Subject: FW: Planning Consultation on: CM/2/21/DOC

The Drainage Engineer has made the following comments on the details submitted.

Application No: CM/2/21/DOC
Registered: 11th January 2021
Site Address: Scyld Horsemere Green Lane Climping BN17 5QZ
Description of Works: Approval of details reserved by condition imposed under CM/21/19/PL relating to conditions 10-schedule of materials & finishes; 11-proposed surface water drainage; 12-discharge of flows to watercourses or for the culverting, diversion, infilling or obstruction of any watercourse on or adjacent to site & 13-maintenance & management of surface water drainage system.

DRAINAGE GA

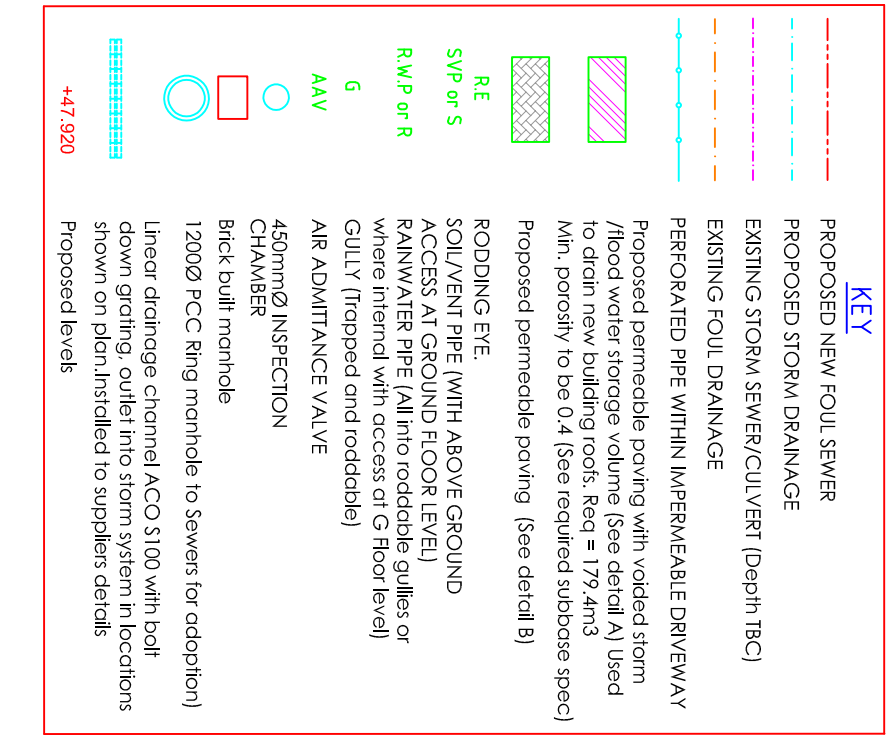
1. The calculations submitted use FSR rainfall and a cv of 0.75, please use Cv=1 or the latest FEH rainfall.
2. The invert level, and flow restriction of the hydrobrake are inconsistent between calculations and layouts. Please update to ensure consistency and include hydrobrake unit reference on surface water drainage layout and construction details.

3. Please ensure modelled slope of permeable paving is accurate.
4. Please detail finish and formation levels of permeable paving.
5. Please detail all pipe diameters and falls on plan.

6. A minimum of 300mm sump depth should be provided upstream of all connections into the permeable paving.
7. Where connections are being made to pipelines rather than direct to manholes – add note ‘all connections to be made using oblique 45 degree junctions’

8. Please indicate bed level of ditch upstream and downstream of proposed point of discharge, as well as at the point of discharge.
9. Please indicate invert level of outfall to ditch clearly. And update the position so this is accurate.

10. No connections are shown to/ from the permeable car park areas. Given the depth of groundwater these structures should be lined and have a positive means of drainage. Please ensure these areas are included within calculations and link to the road drainage.

STORM WATER DISCHARGE INTO PERMEABLE
PAVING SYSTEM DETAIL

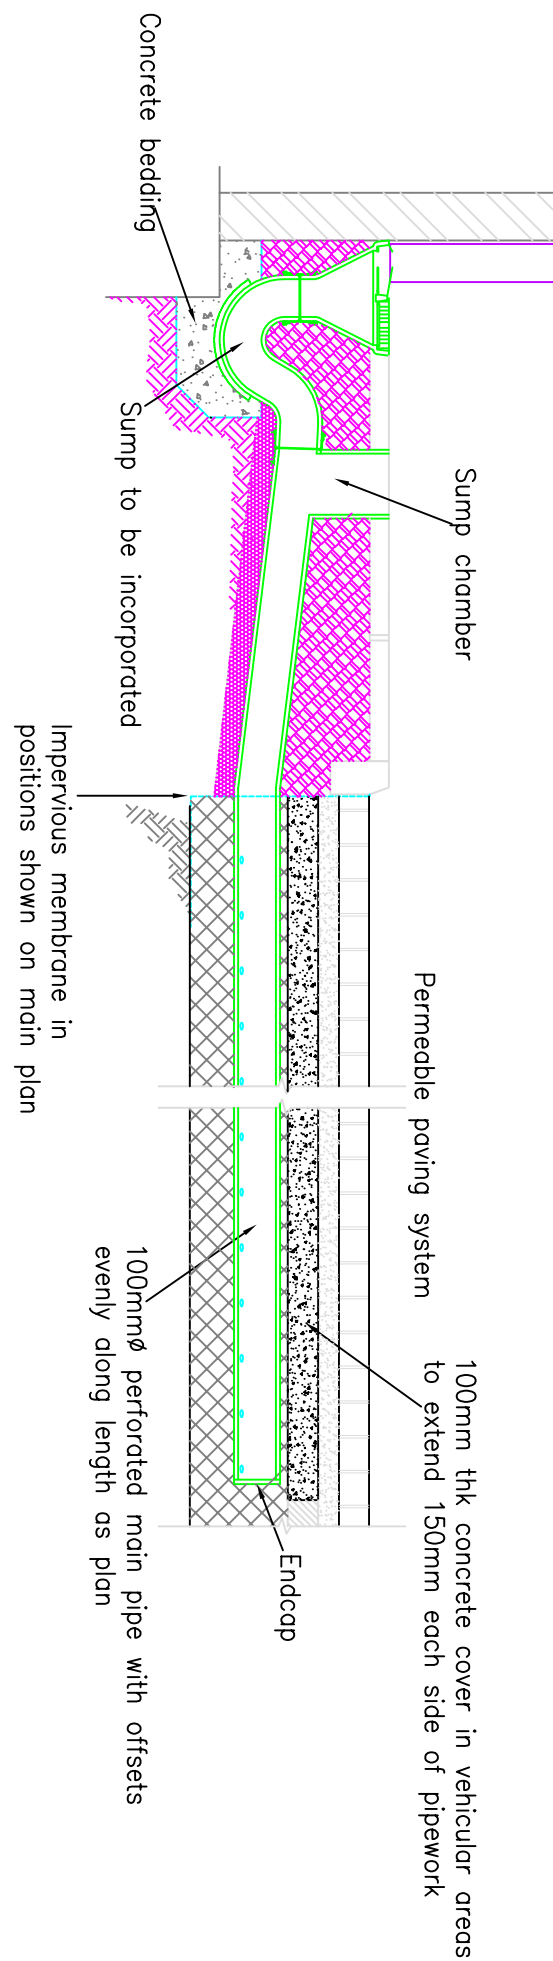
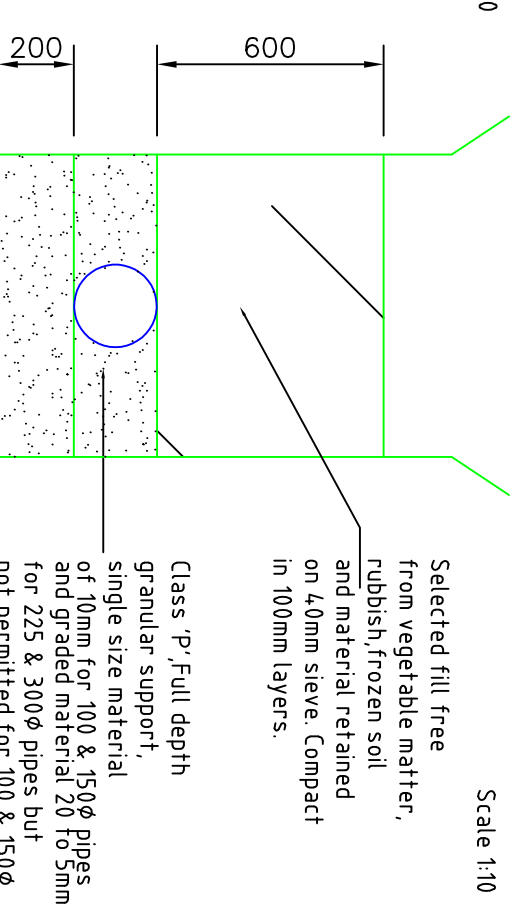
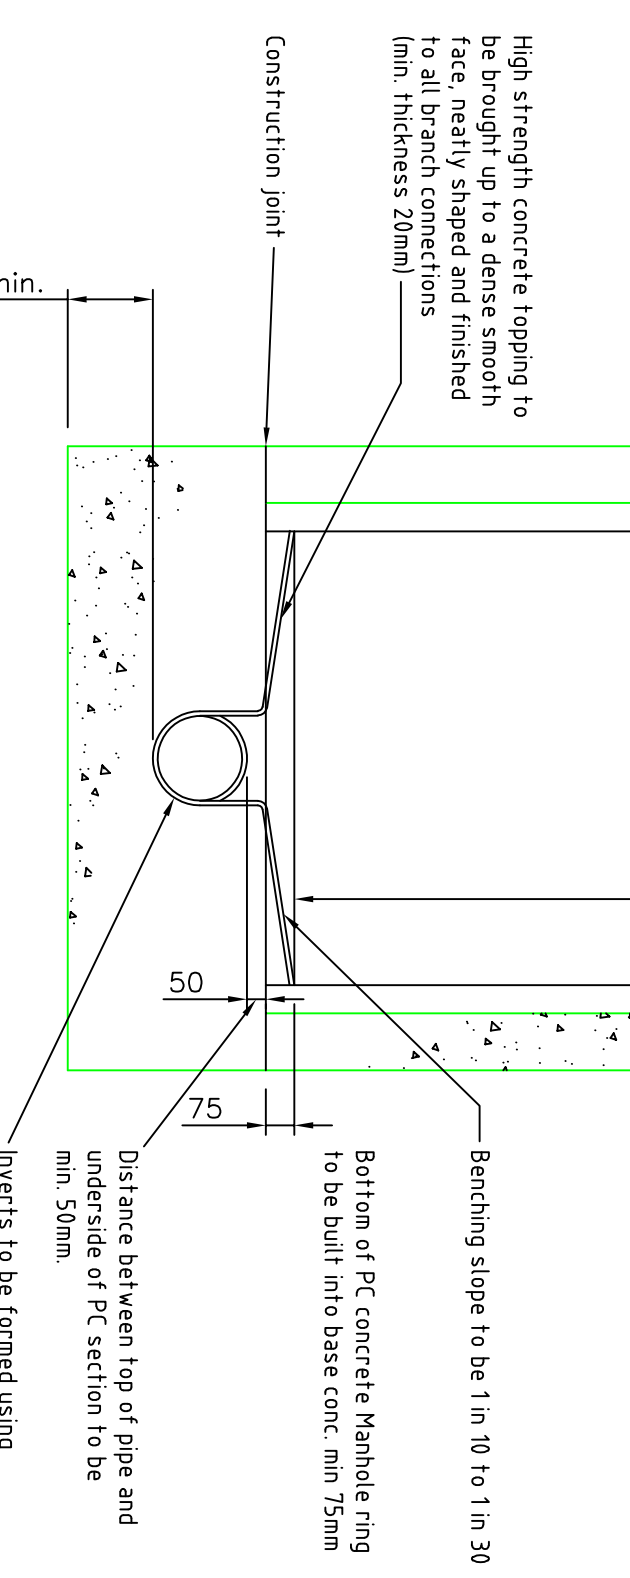
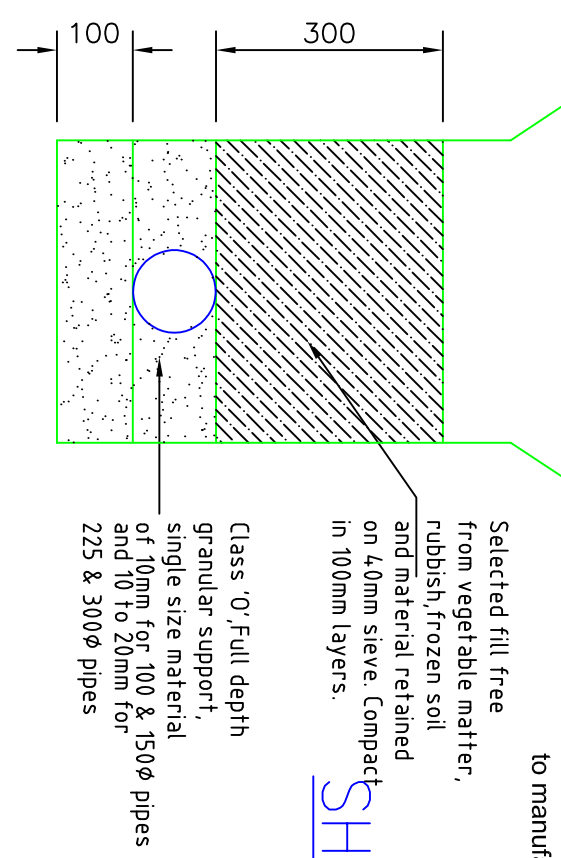
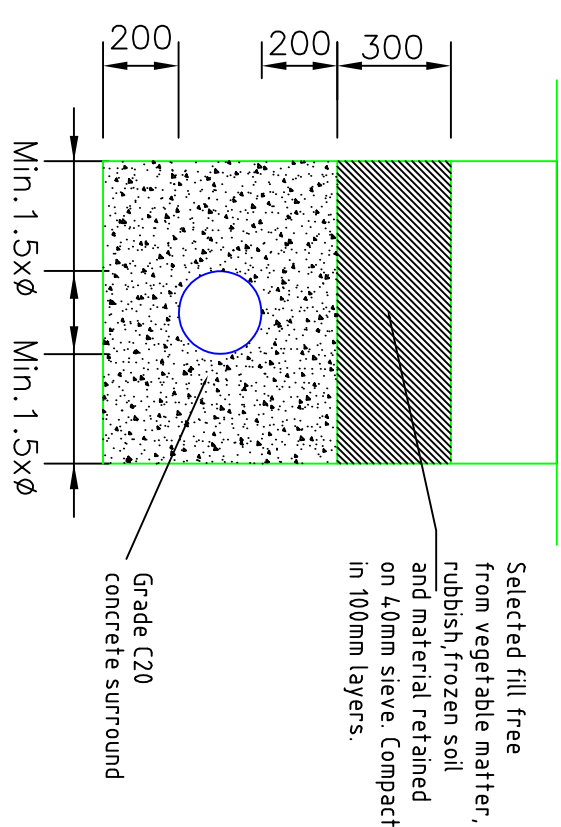
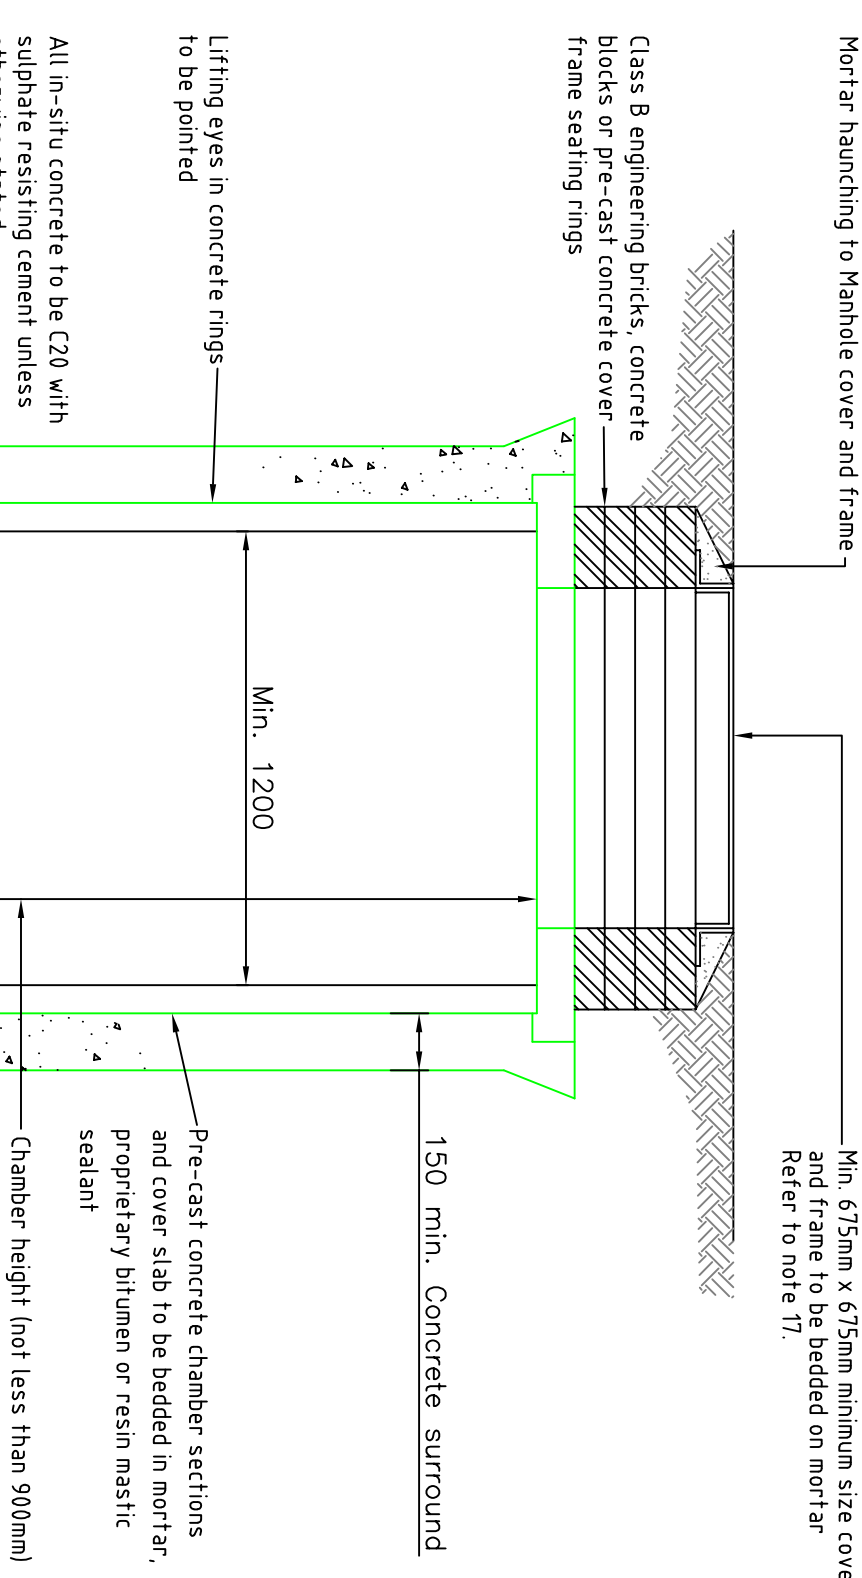
Dear Mr Rossner,

Condition 11- surface water drainage design

11. Please provide construction detail drawings of : hydrobrake (site specific); drainage channels, catchpits, and proposed headwall.
12. The permeable paving details must show an impermeable membrane around the side and base.

13. The permeable paving details must indicate minimum depth of sub-base and sub-base material.
14. I note that it is proposed to have a 100mm thick concrete cover slab over the top of the perforated main pipe, with 150mm each side of pipe work. This would have to be constructed very carefully so as not to cause concrete ingress into the perforated pipe, and it will also result in a strip of road being impermeable. Has the use of diffuser units been considered instead with a small fall in formation over the site? The outlet diffuser unit would have to be at the base of the sub-base. As should the pipe at the downstream end if this is to remain.
